From: Cindy Flood <cindy.flood@esmcivil.com>
Sent: Tuesday, May 6, 2025 10:59 AM
To: Bradley Gasawski; lwedin@suncadia.com; rcrispin@lwhsd.com
Cc: Jamey Ayling; Zach Torrance-Smith; Ellie Myers
Subject: BL-25-00006 Suncadia Ph 3 Div 18 - Deemed Incomplete
Attachments: BL-25-00006 Suncadia Ph 3 Div 18 - Notice - Deemed Incomplete.pdf

From: Bradley Gasawski <bradley.gasawski@co.kittitas.wa.us>
Sent: Tuesday, May 6, 2025 9:47 AM
To: lwedin@suncadia.com; rcrispin@lwhsd.com; Cindy Flood <cindy.flood@esmcivil.com>
Cc: Jamey Ayling <jamey.ayling@co.kittitas.wa.us>; Bradley Gasawski <bradley.gasawski@co.kittitas.wa.us>; Zach Torrance-Smith <zach.torrancesmith@co.kittitas.wa.us>; Ellie Myers <ellie.myers@co.kittitas.wa.us>
Subject: BL-25-00006 Suncadia Ph 3 Div 18 - Deemed Incomplete

Please see the attached correspondence regarding your BLA application (BL-25-00006 Suncadia Ph 3 Div 18). I have also placed a hard copy in the mail. Please let me know if you have any questions.

JOB NO. 998-847-022-0202 | DATE: 2025-04-17
 DRAWN: C.A.F. | SHEET 1 OF 3

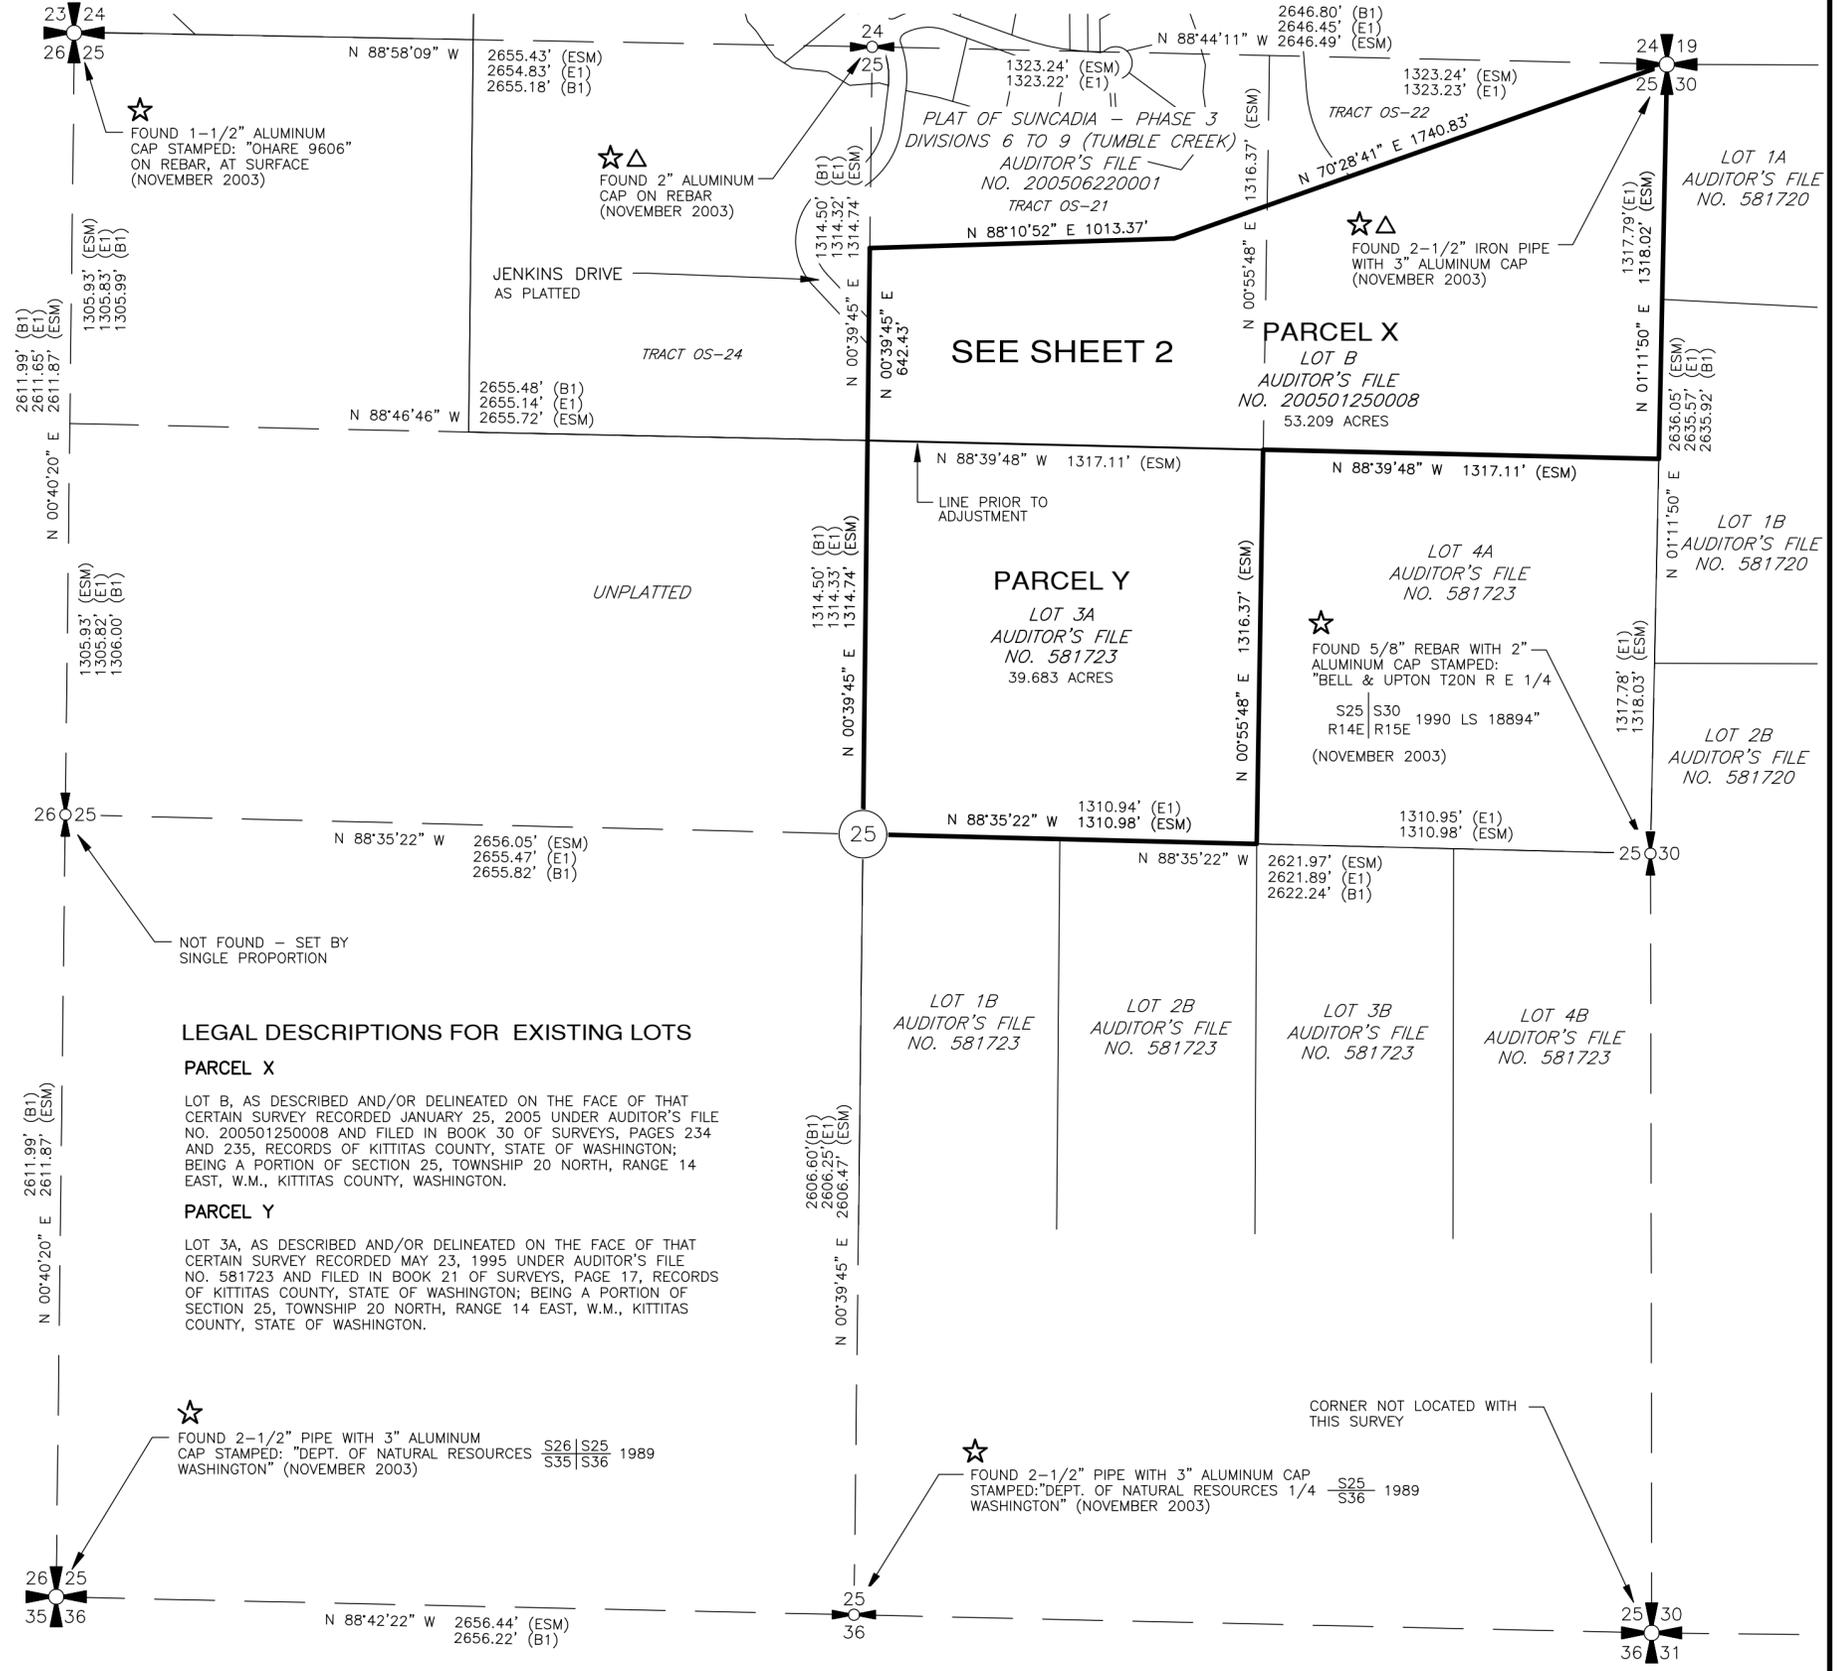
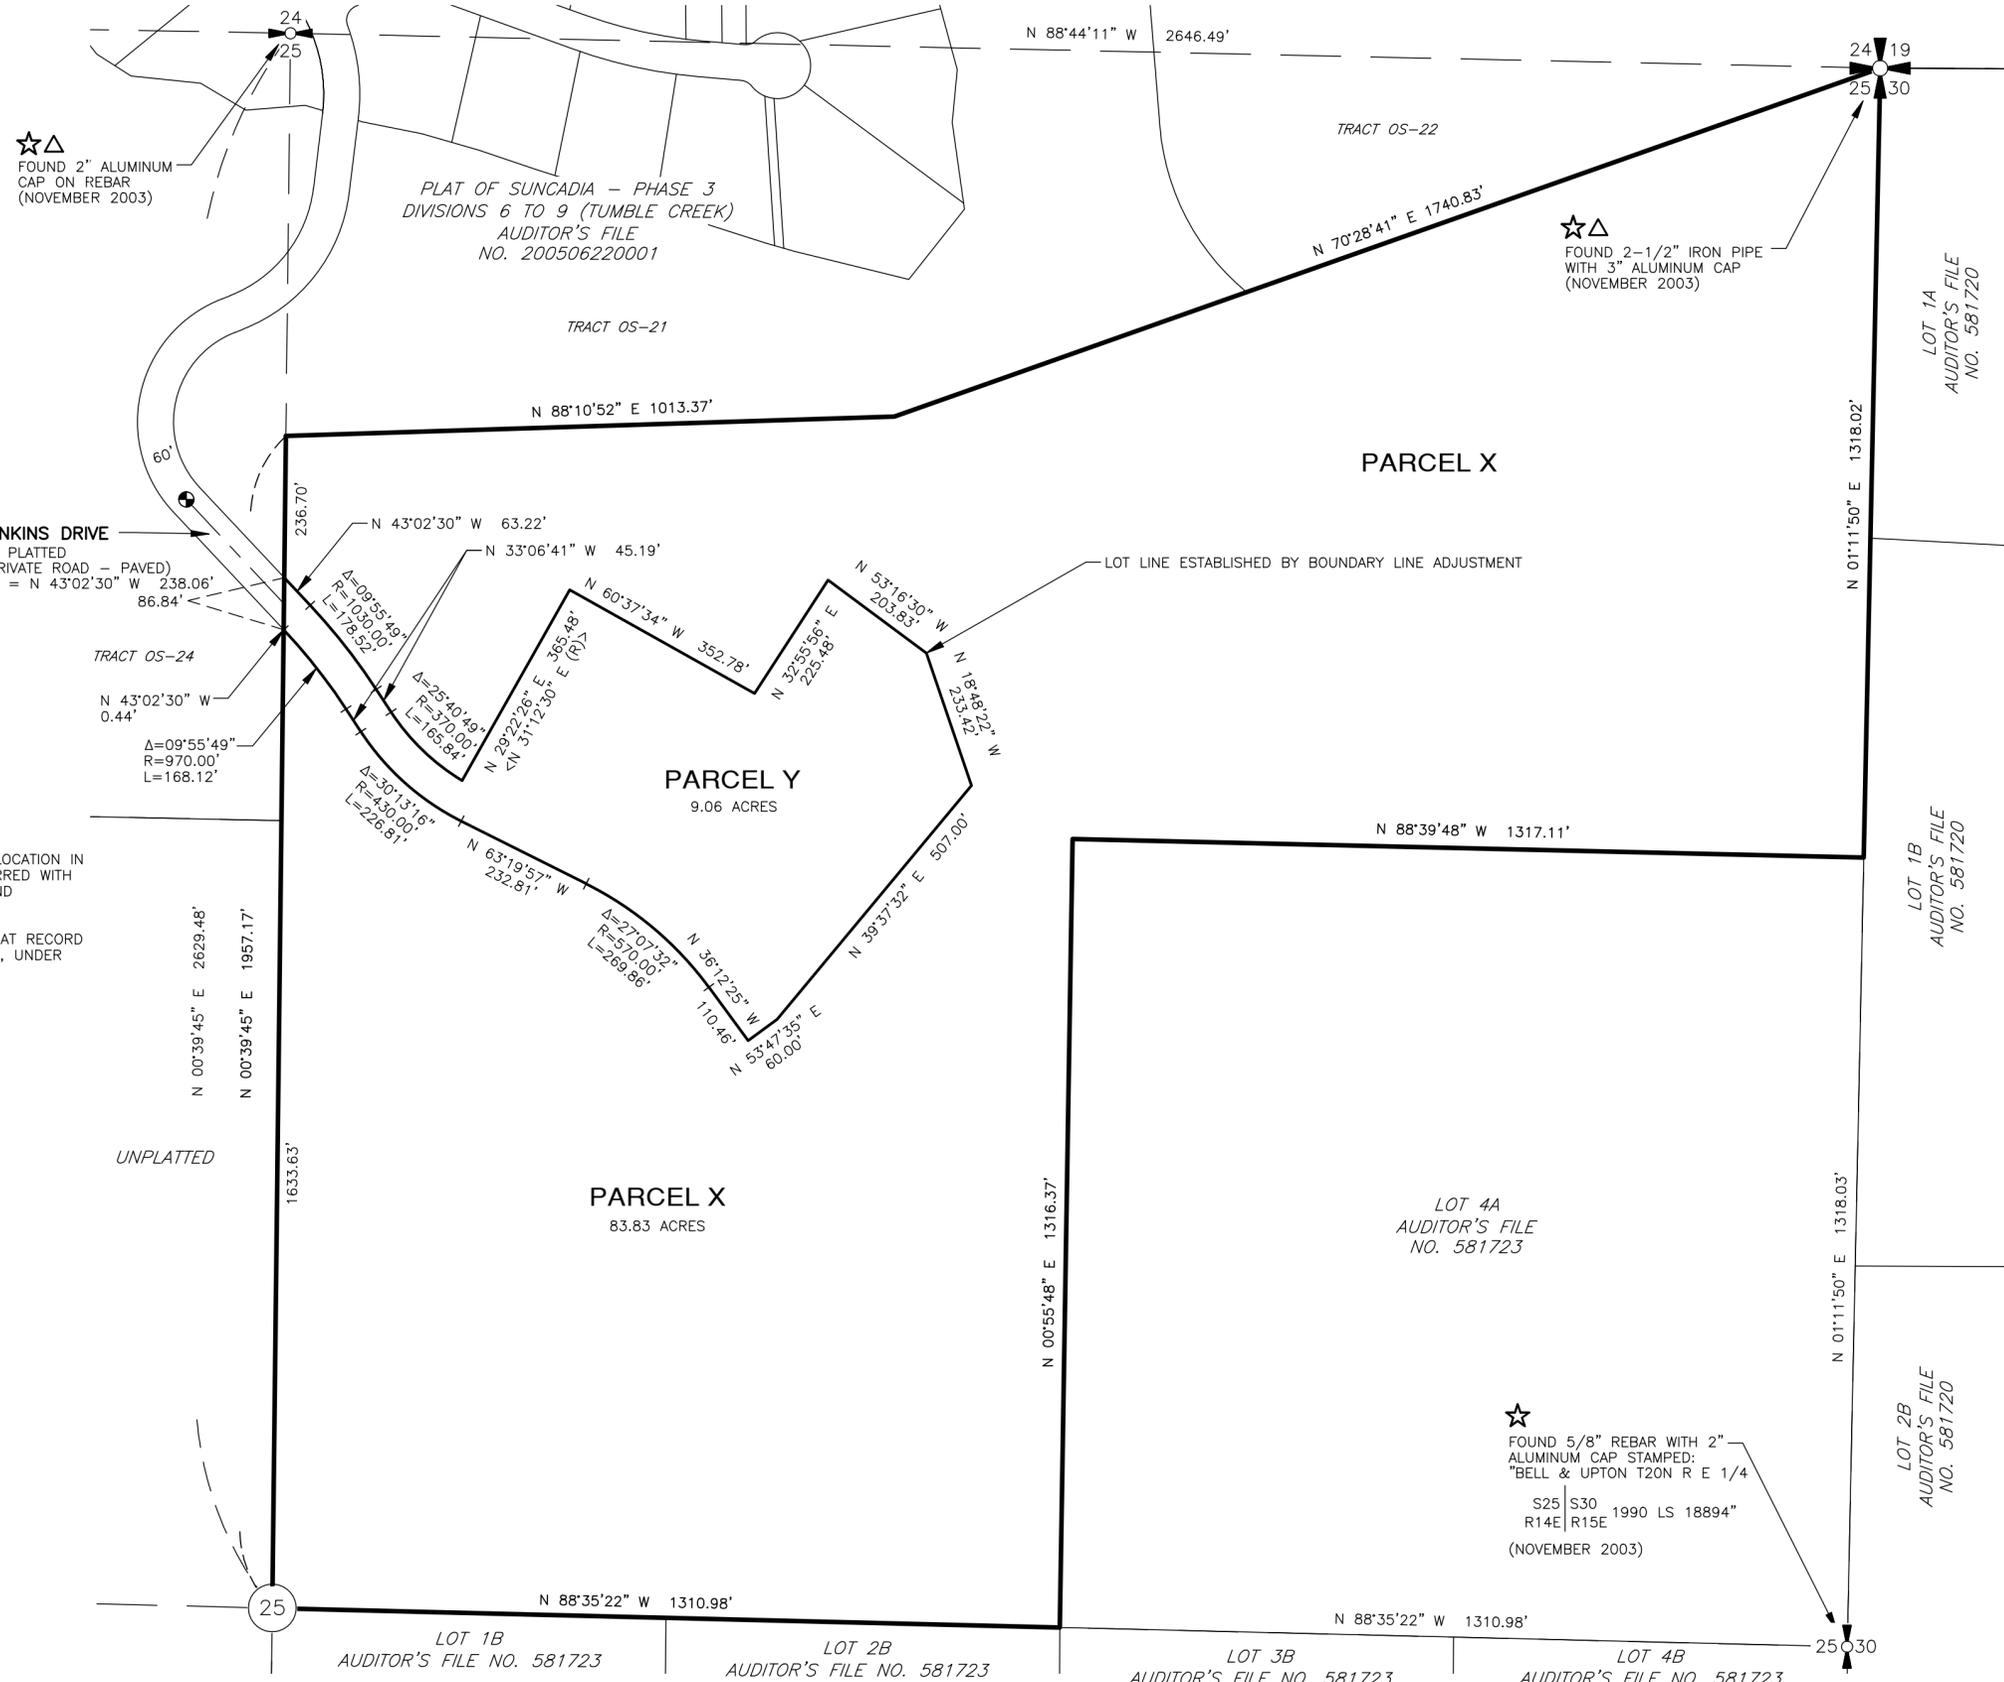
Regarding Comment 1: The application uses the current assessor's acreages due to issues in the past when there were discrepancies. The reason that the acreages on the survey map do not match is that those acreages are based upon a field survey. The survey represents the acreages that we will use as further subdivision is completed.

Regarding Comment 2: On the application, the new parcel acreage is different by 0.01 acre due to rounding. If it is an issue, the acreage of 9.36 acres can be changed to 9.35 on the application.
